Submission of a Non-Material Amendment to Planning Permission Ref: 20/P/01273 at 20 The Street, West Horsley, Leatherhead, KT24 6AX

We hereby submit a non-material amendment (S96a) to amend condition 1 of the approved development, under application ref: 20/P/01273.

Drg No: **FD 19 - 1756 - 112**

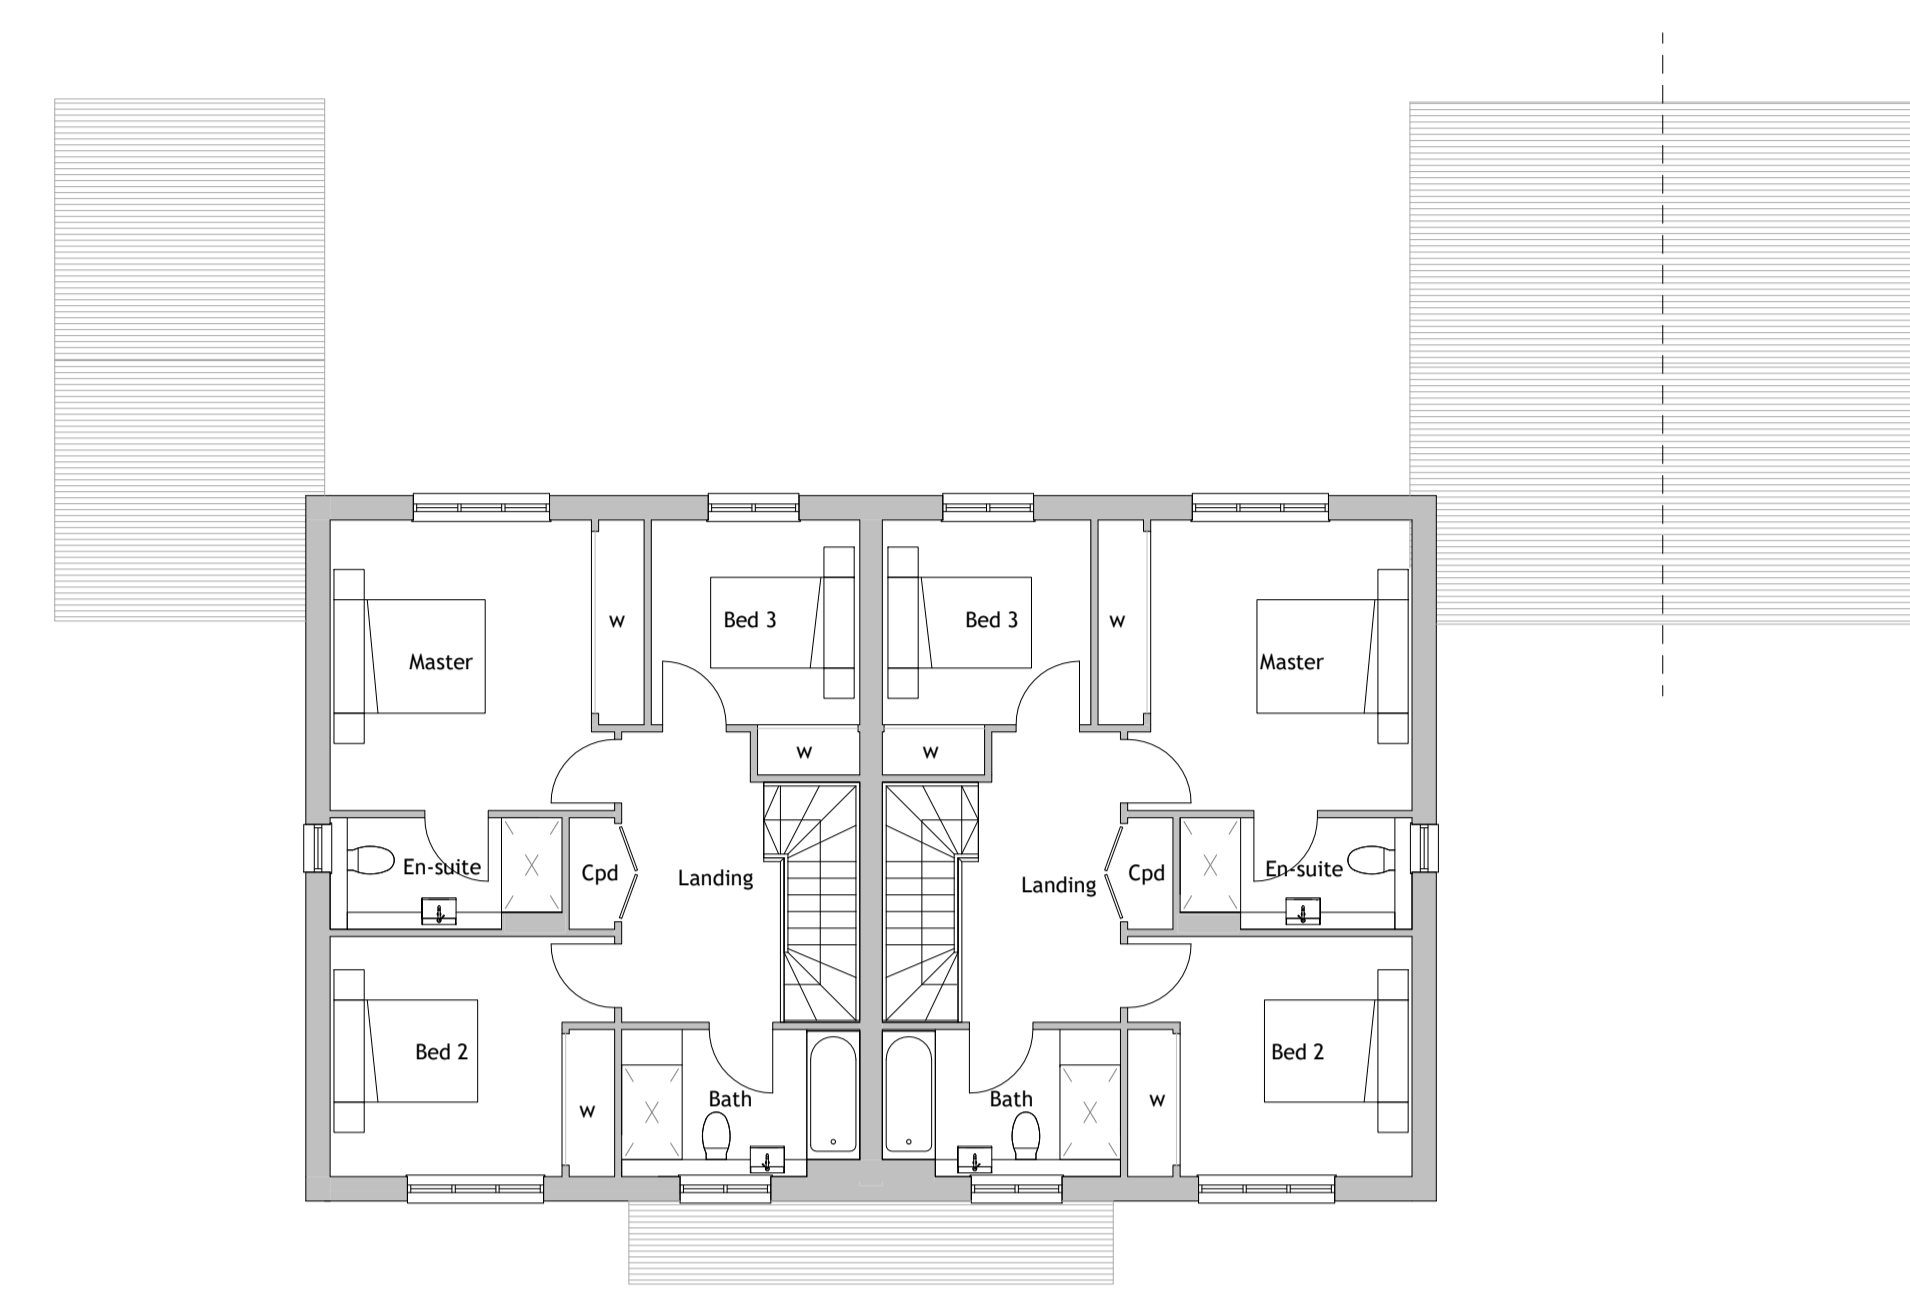
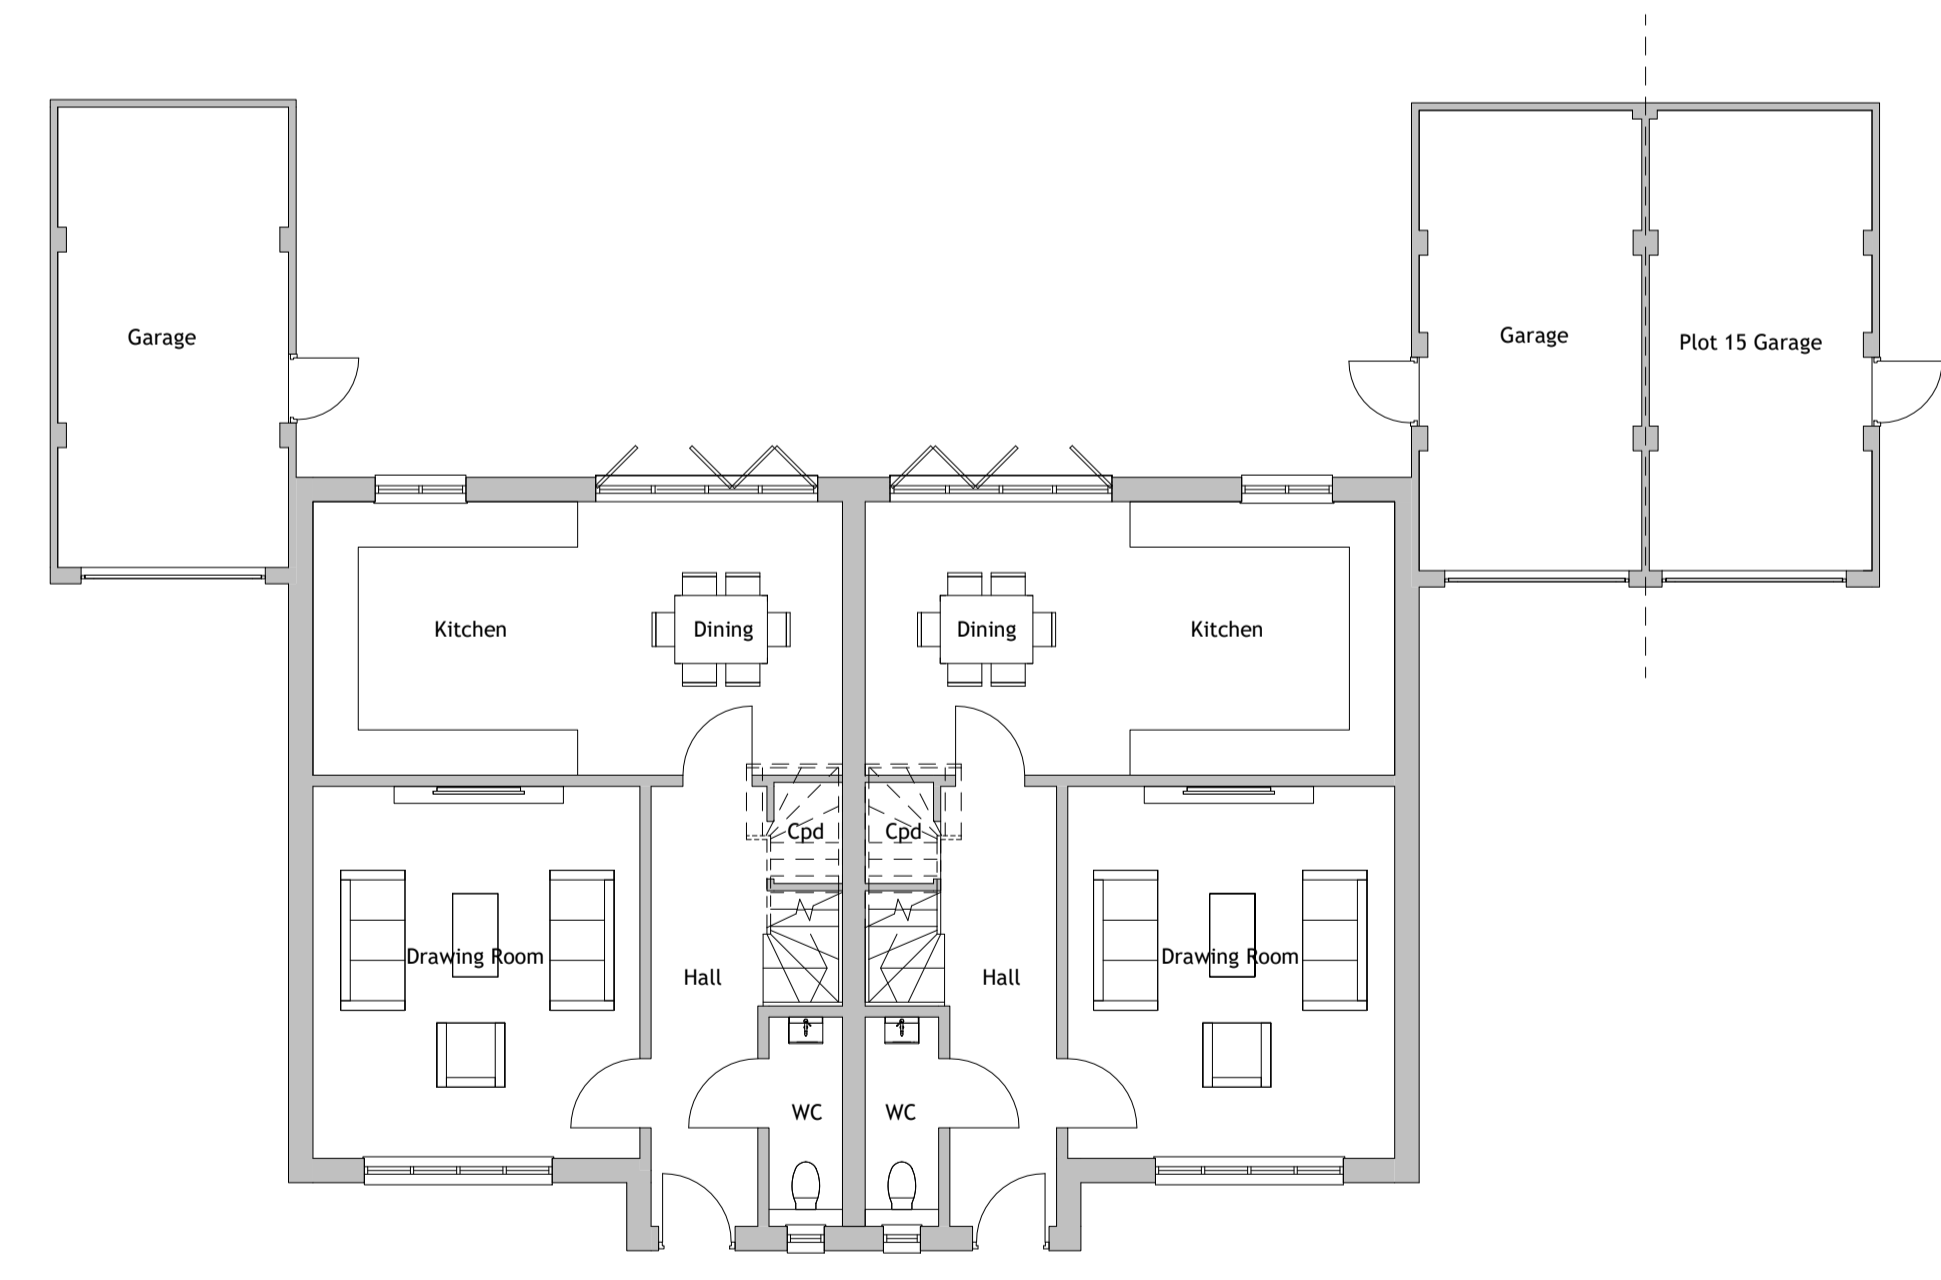
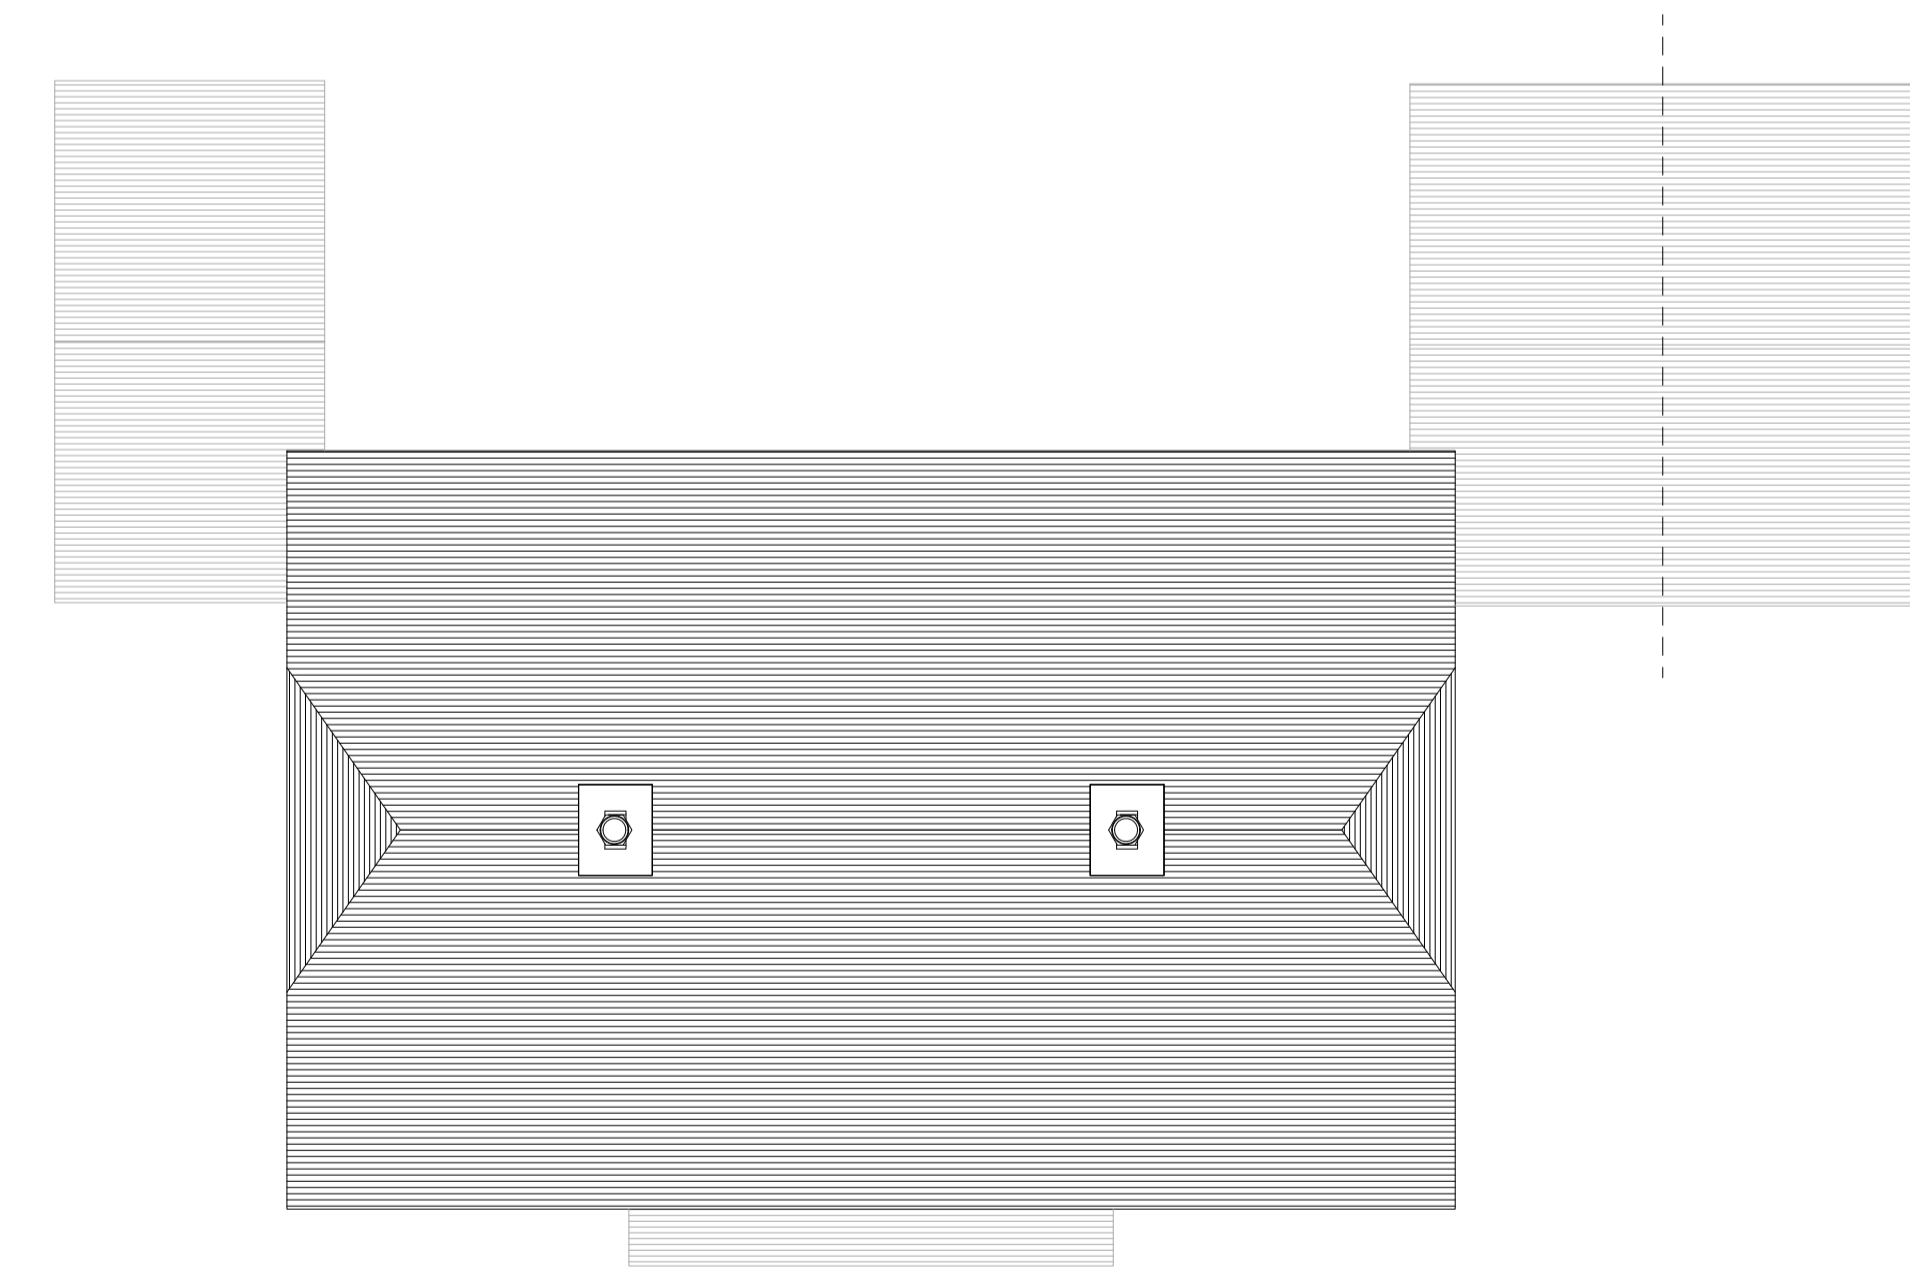
This amendment seeks only to relocate the double garage at plot 12, to adjoin the garage at plot 13. There is a legal covenant through the garden and driveway of plot 12 that restricts built structure in that area, therefore the location of the garage needs to be moved, so it falls outside this area.
